Re: PA23-005 – Creekside PRD – Technical Review 1
7808 40th Street, 7811 & 7715 40th Street NE, APNs 29050200100200,
29050200100300, and 29050200100400

BINDING SITE PLAN / PLANNED RESIDENTIAL DEVELOPMENT COMMENTS

**HORIZON VIEW HOLDINGS, INC.**  
**CREEKSIDE**  
 PRELIMINARY ROAD SECTIONS

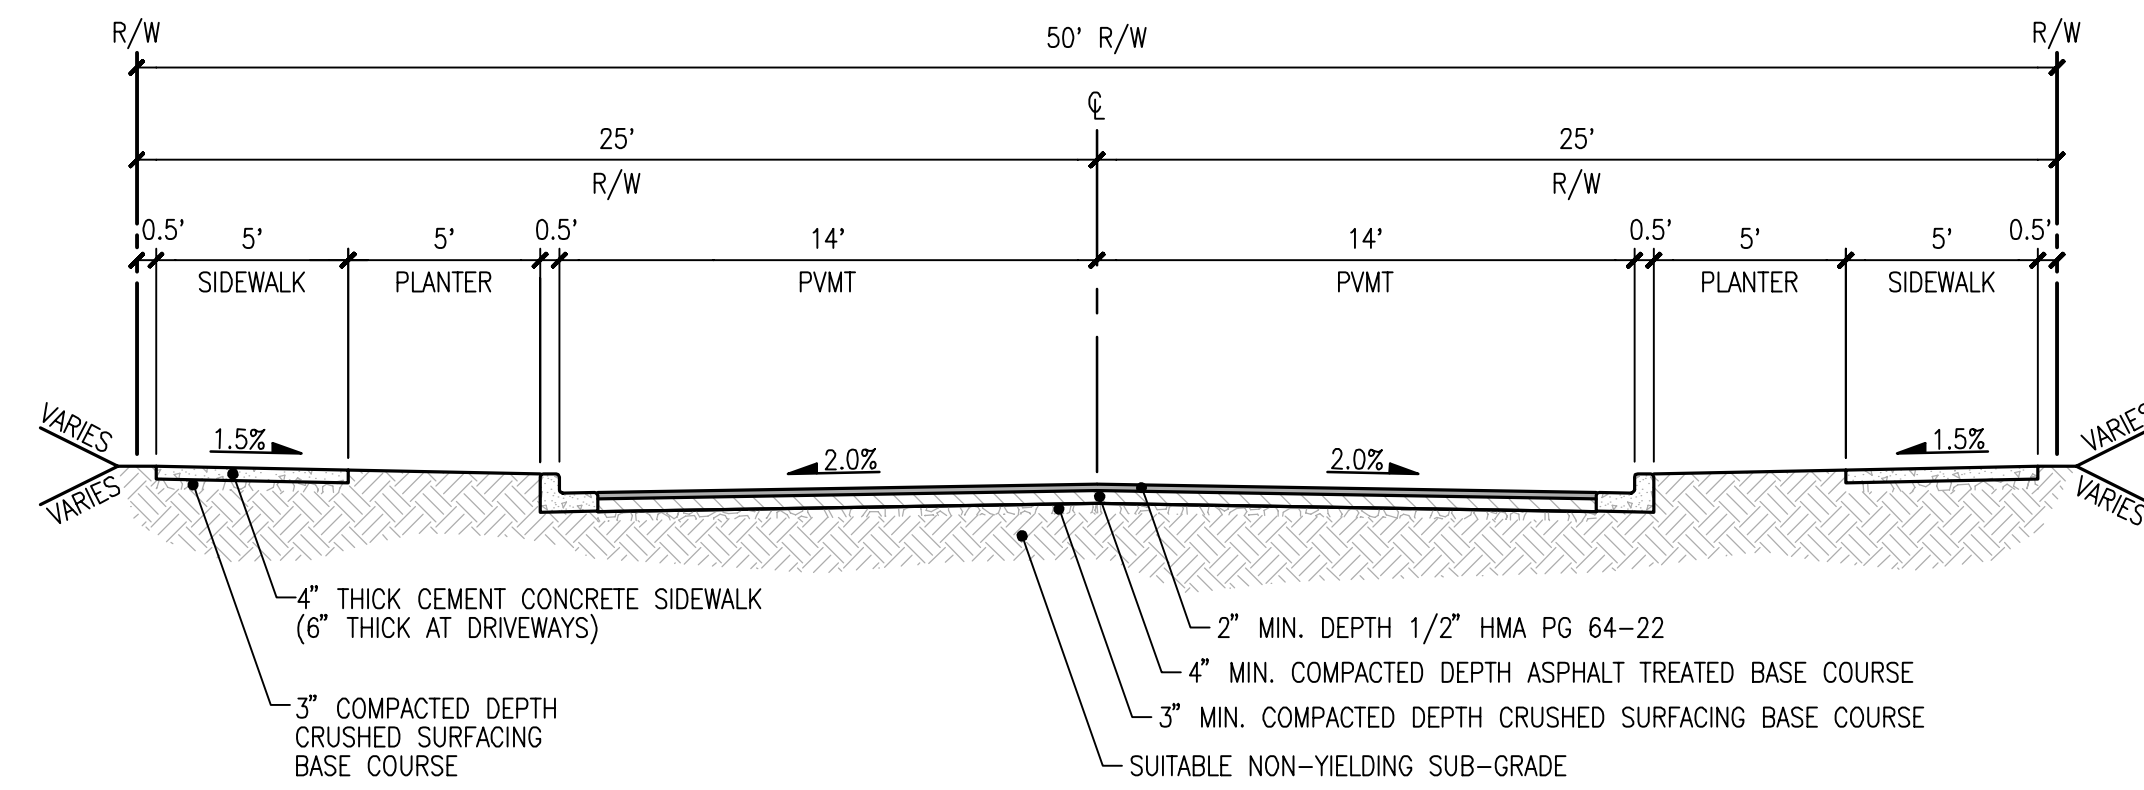
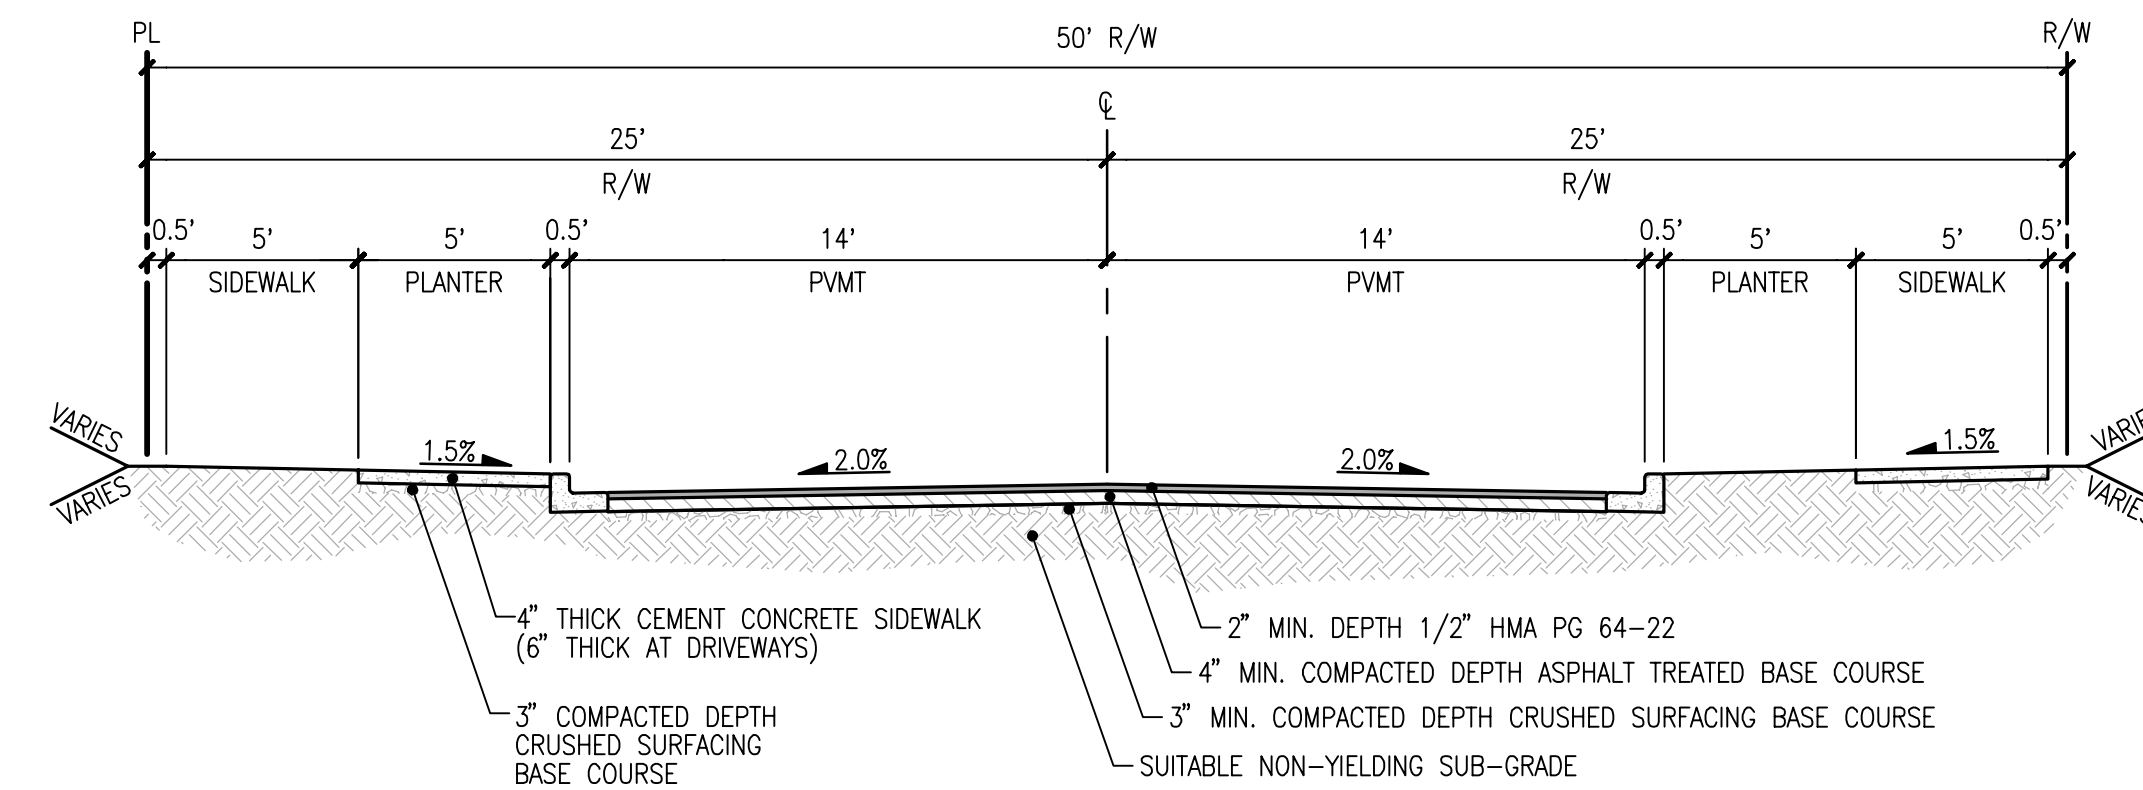
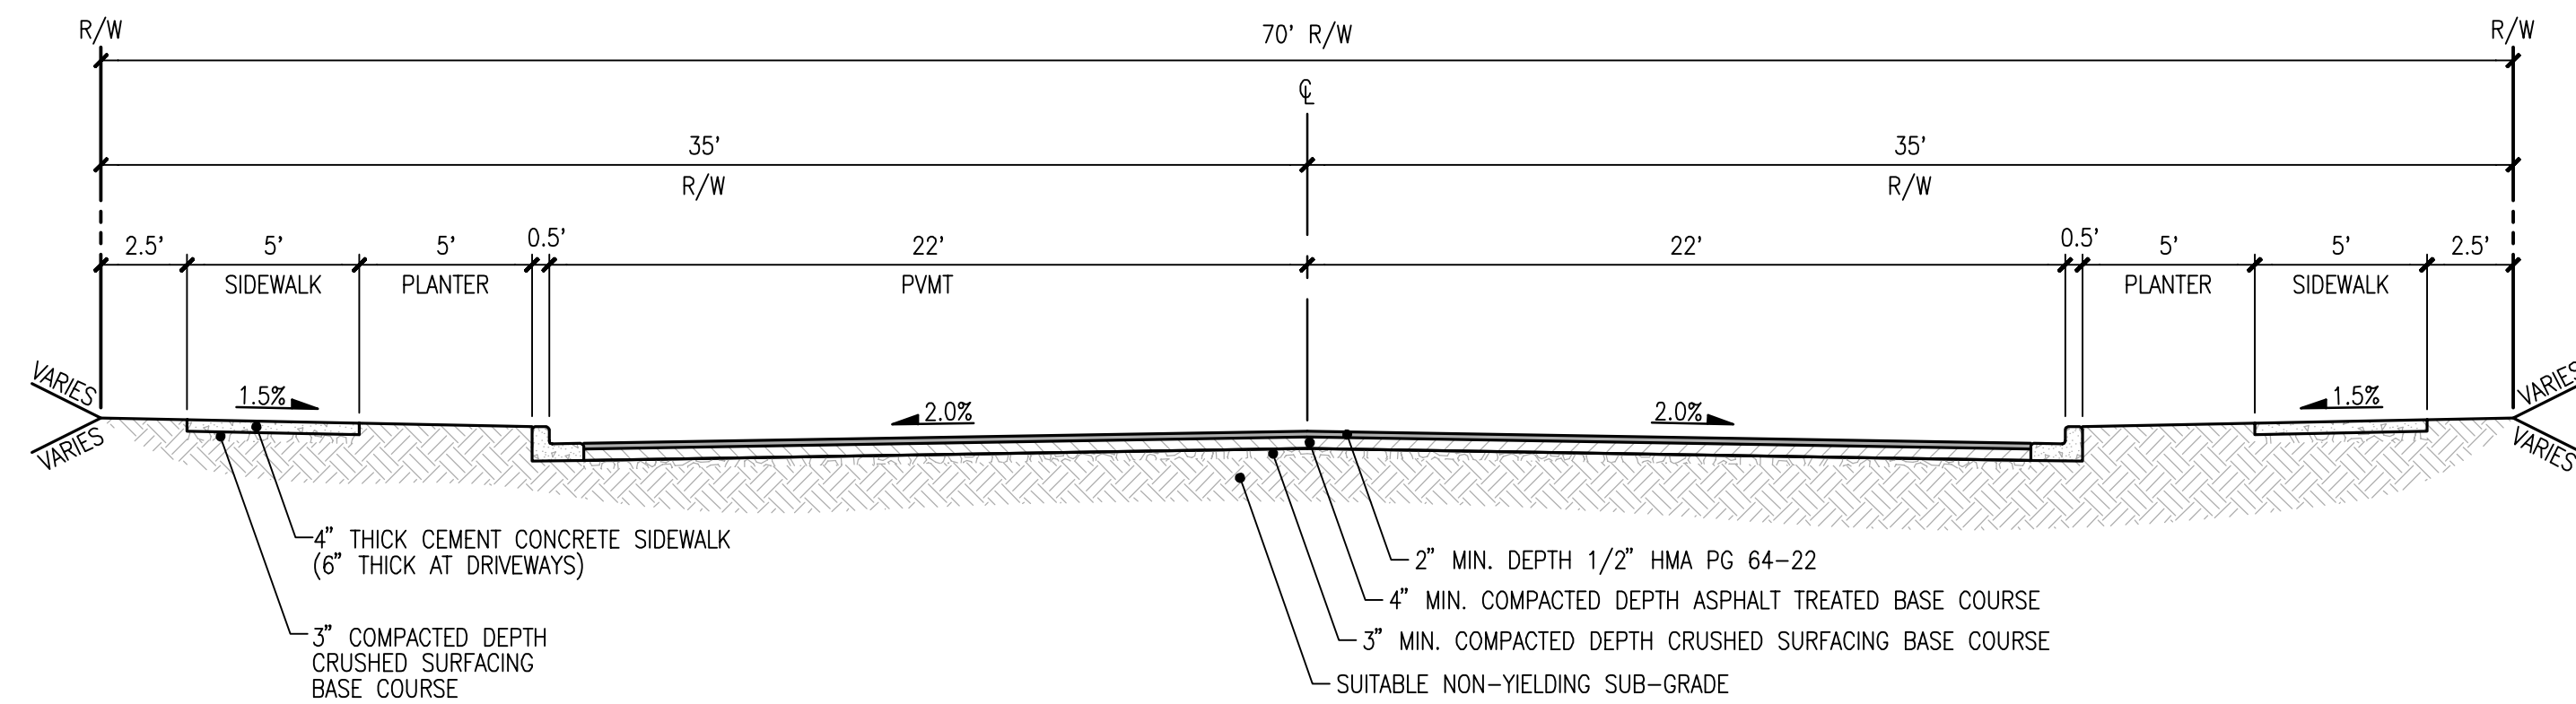
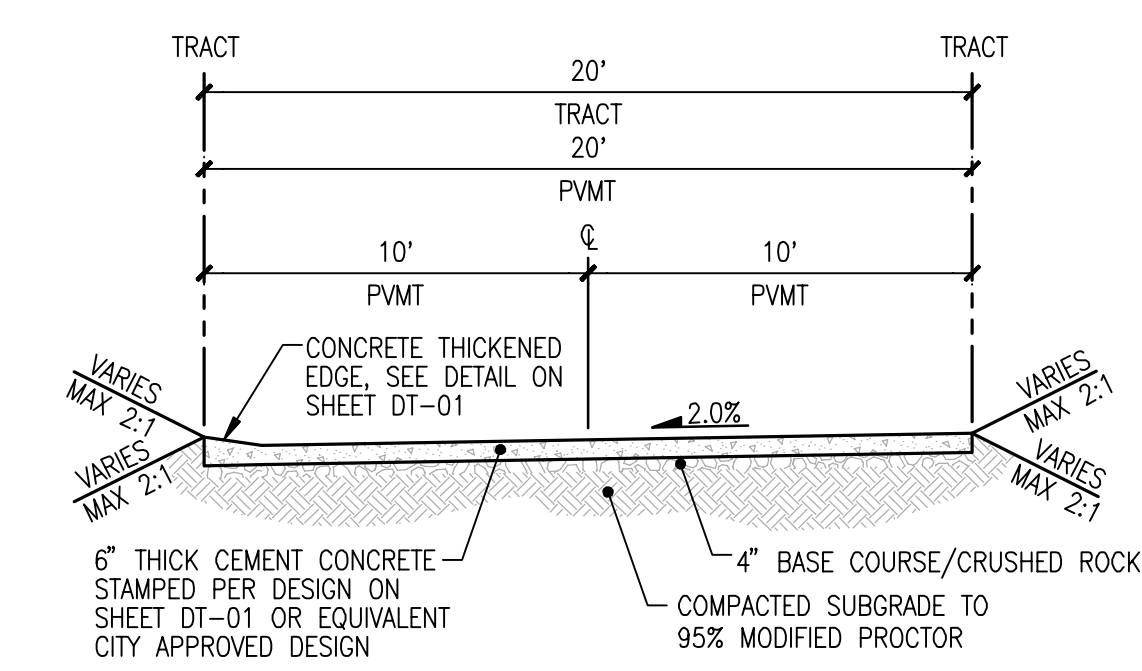
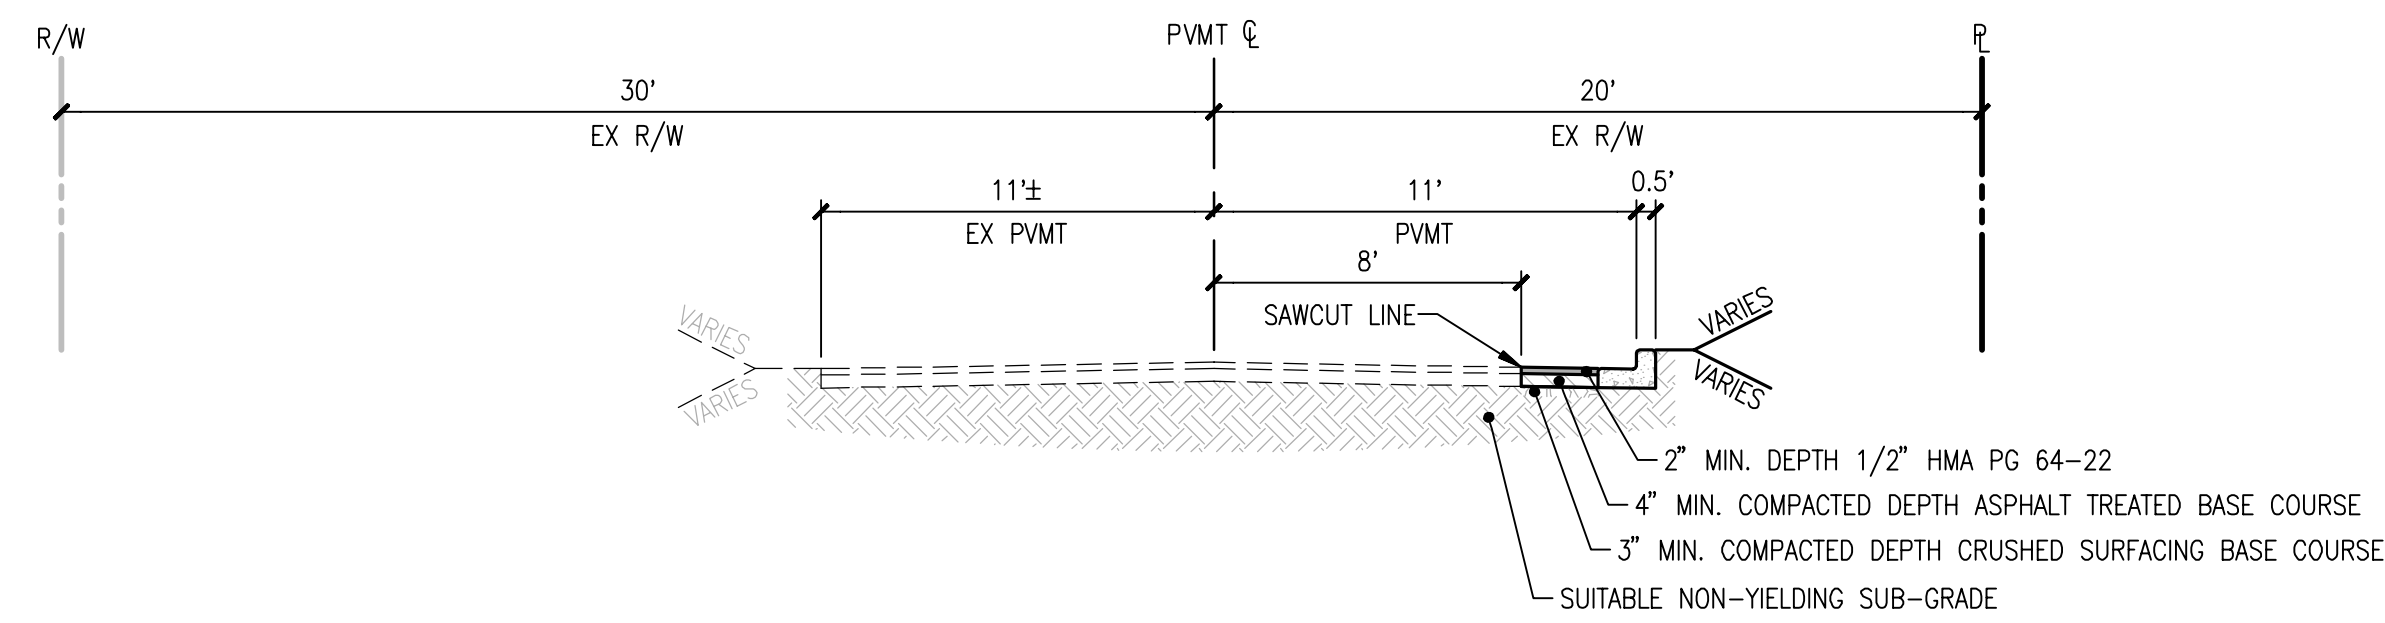
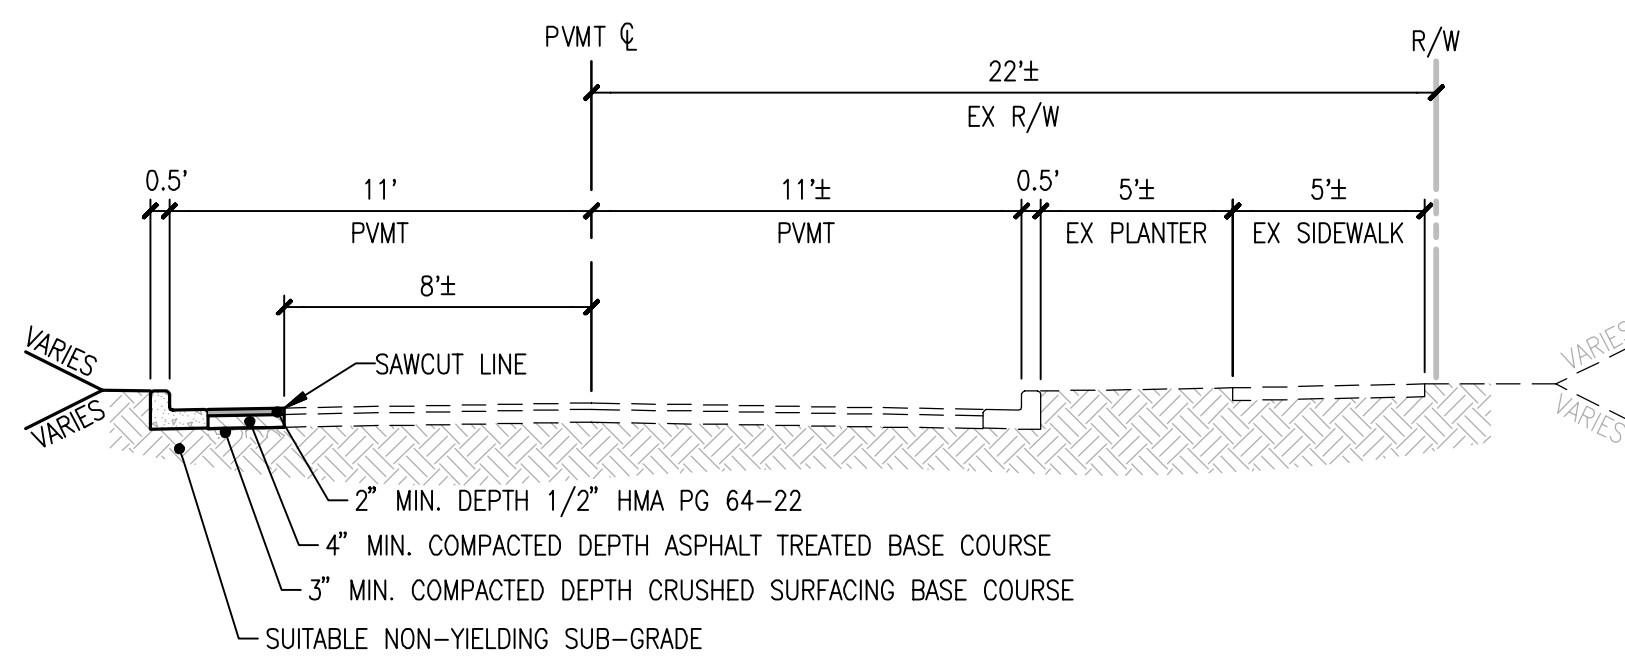
- a. 79th Ave NE is classified as an arterial and is to be built as a 3 lane road, compliant with SP 3-201-003 of the EDDS. Curb, gutter and sidewalk must also be installed. This project will be responsible for all frontage improvements along the site's frontage. Please show more detail on next submittal of parcel 00590700032203/00590700032201 including property lines to differentiate where frontage improvements will not be needed.

- b. 44th St NE is classified as an arterial and is to be built as a 3 lane road with bike lanes. Curb, gutter and sidewalk must also be installed. See standard plan 3-201-004 of the EDDS. Frontage improvements will be required along 44th St NE to the east to 79th Ave NE.
